C.RO Ports Killingholme Limited

The Able Marine Energy Park Development Consent Order

Planning Inspectorate Reference: TR030001

**Written summary of the oral representations of C.RO Ports Killingholme Limited at
the Issue Specific Hearing on marine issues**

Drawing file: published-documents / TR030001-003483-201112 TR030001 AME - 02006 E Indicative Masterplan.pdf

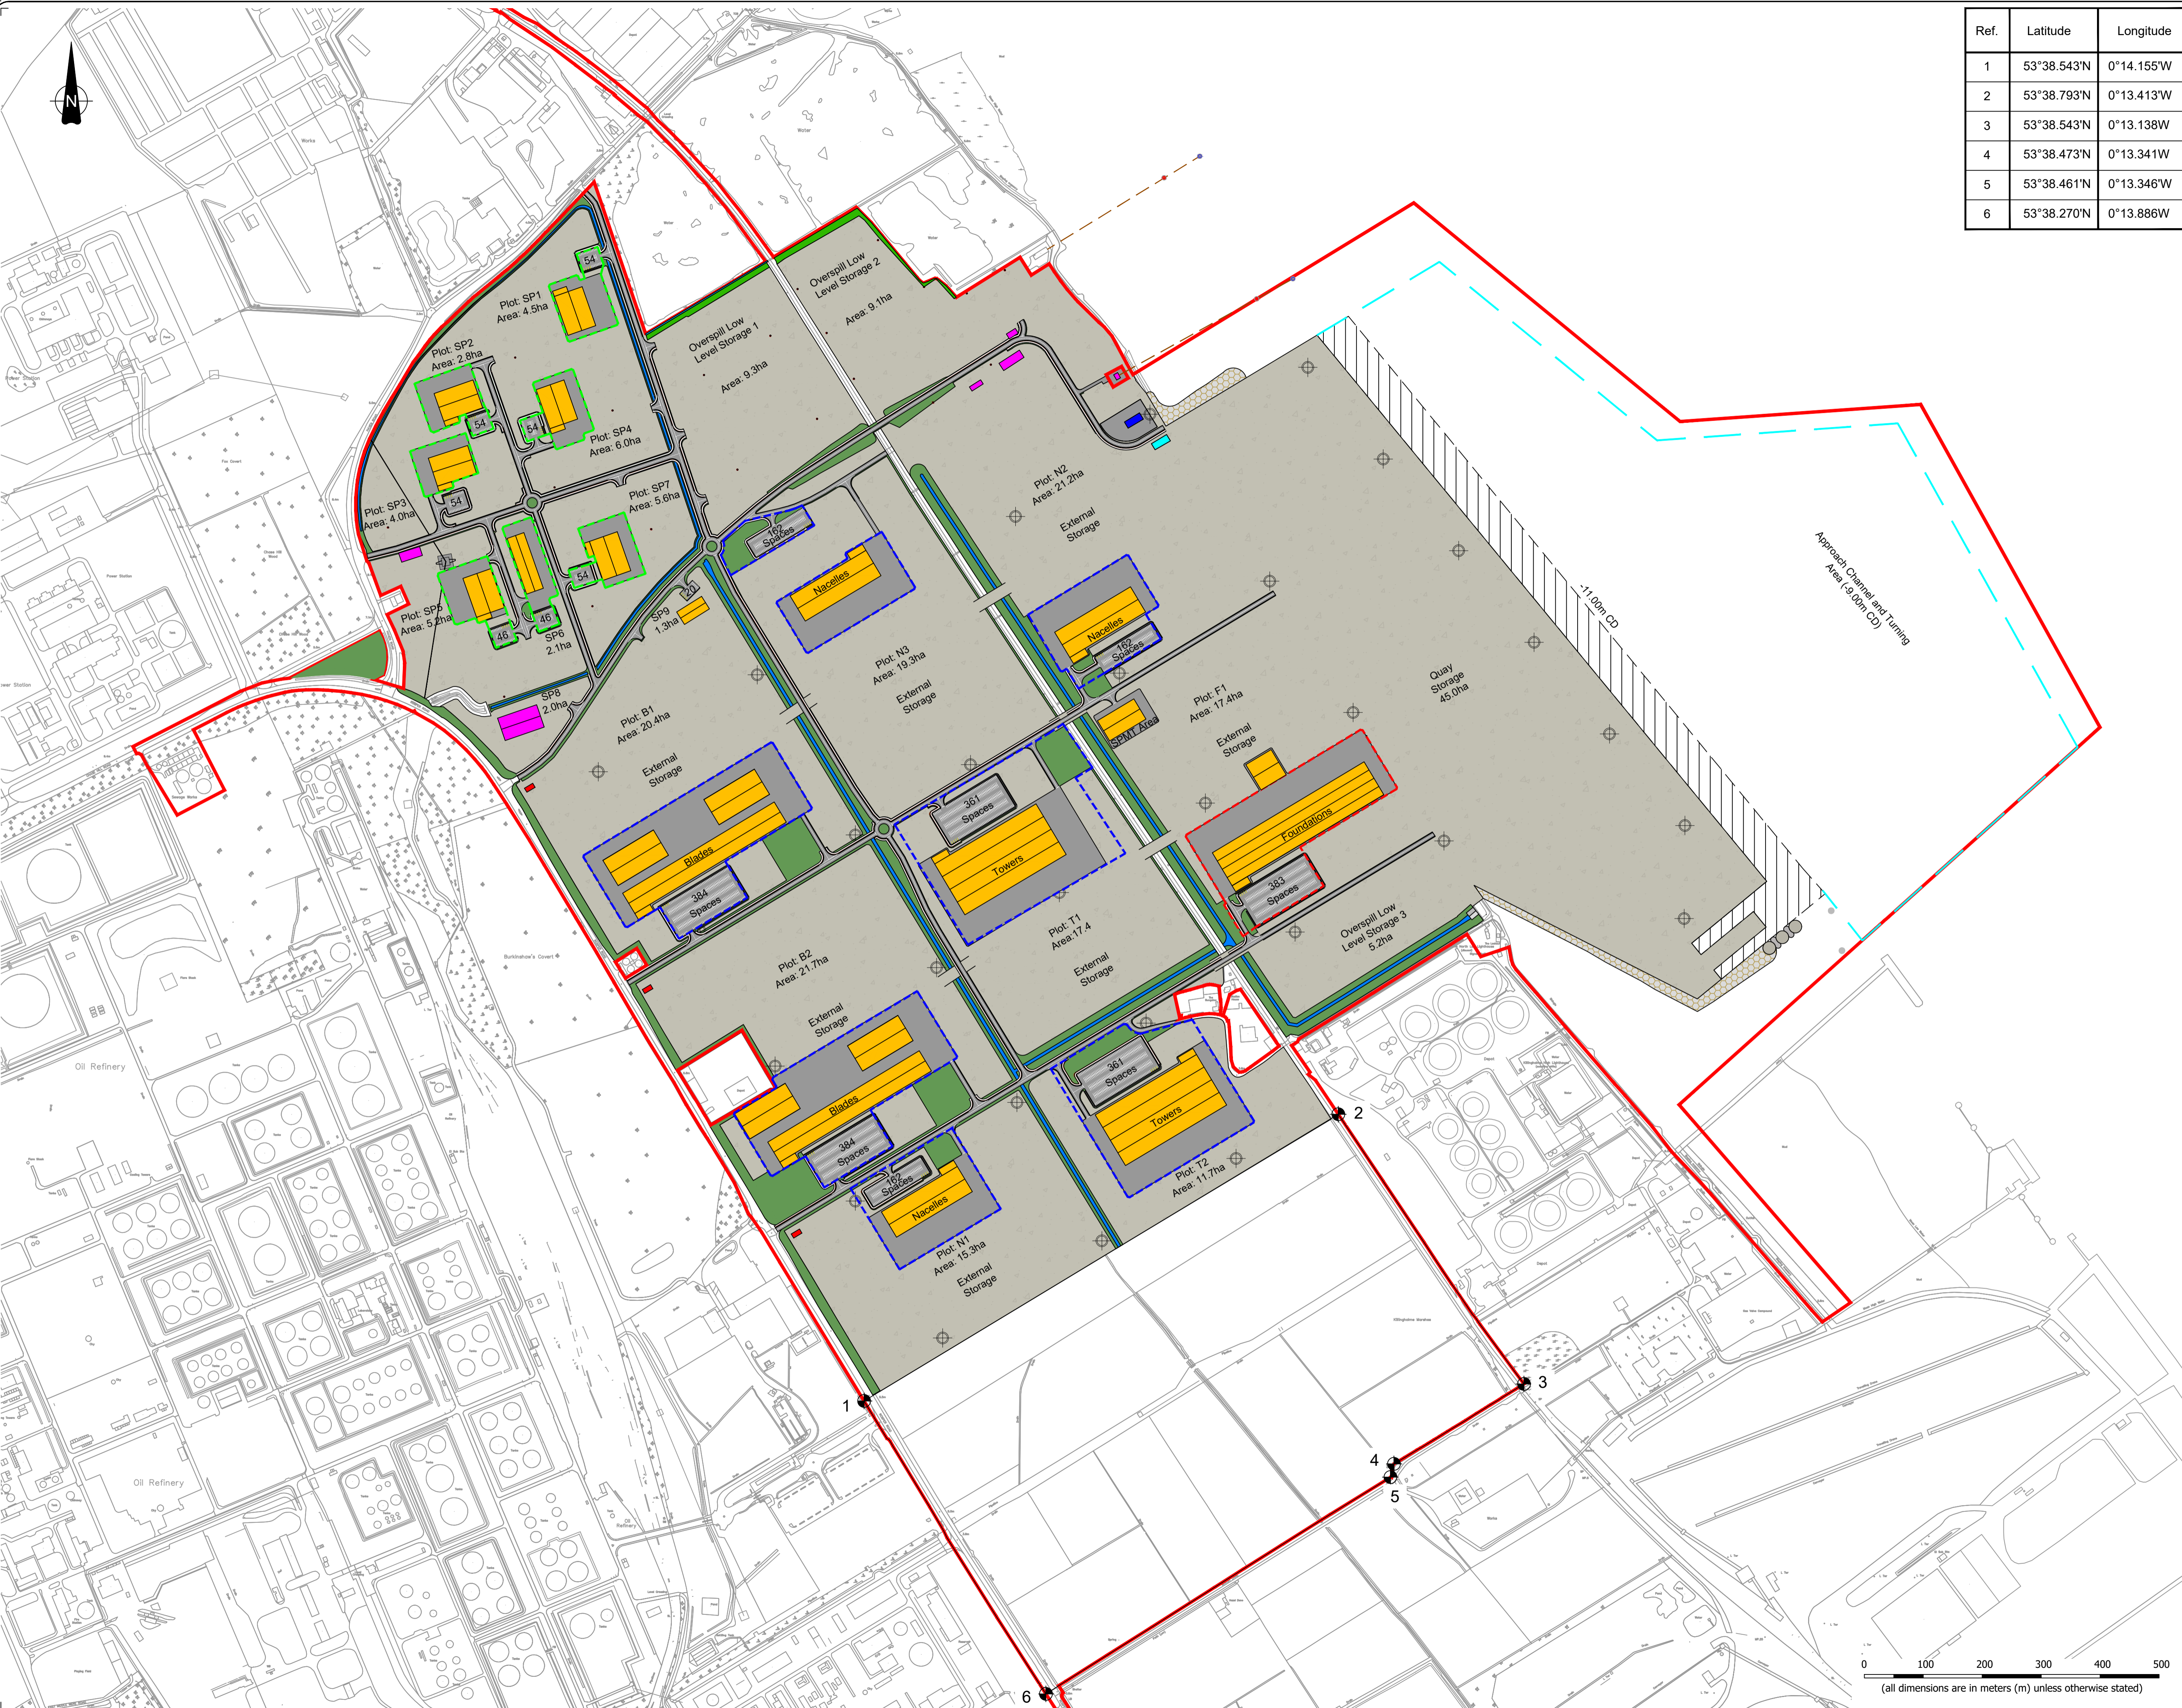
- 4.2 A number of revisions to the Application have been proposed since the Application date. These comprise new drawings (for example a new Works Plan for the proposed railway loop within AMEP), although additional planning/other drawings have not been updated e.g. the Indicative Masterplan. A comprehensive set of revised drawings, with an indication of which drawings have been replaced, is important. In connection with this, C.RO would welcome confirmation from Able that the environmental impact assessment contained in the ES is not affected by the details that have changed since the date of the Application.
